Application No: EP/68/26/HH
Site Address: 8 Tamarisk Way East Preston BN16 2TF
Description of works: Two storey front extension. New windows. New cladding to the first floor.

Thank you for your internet representation made on 7th August 2026 which has been recorded as no objection with the comments as follows:

Proposed North Elevation

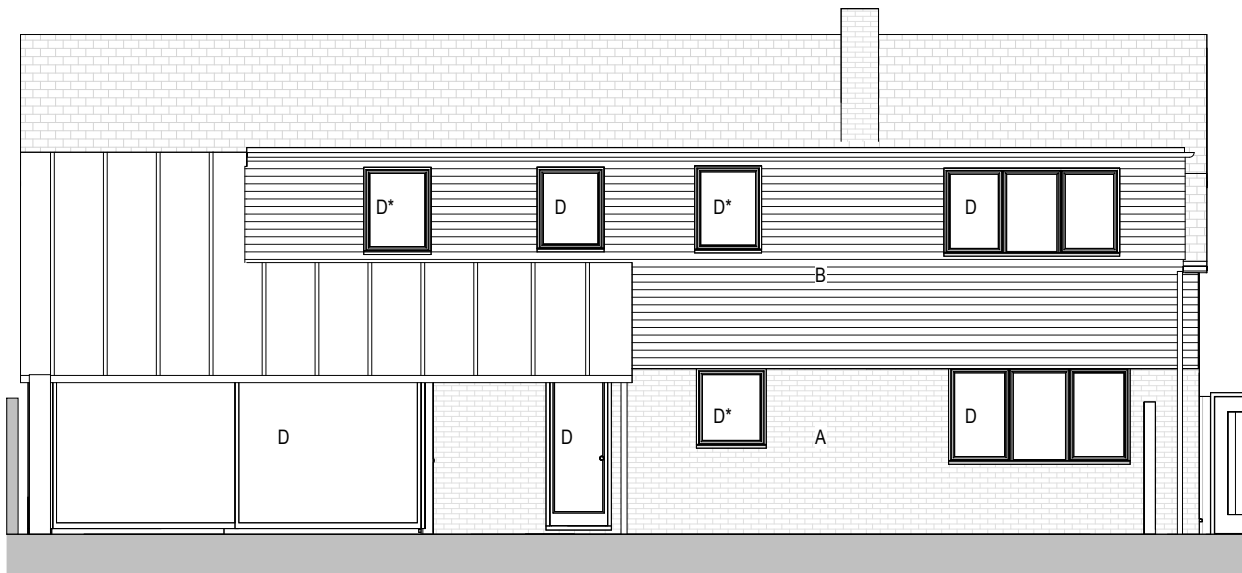
Our only comments in respect of this application are that the replacement windows to the north upstairs side of the property remain the same size as they are at present and are not enlarged or made into Juliet balconies which would result in overlooking in the winter months
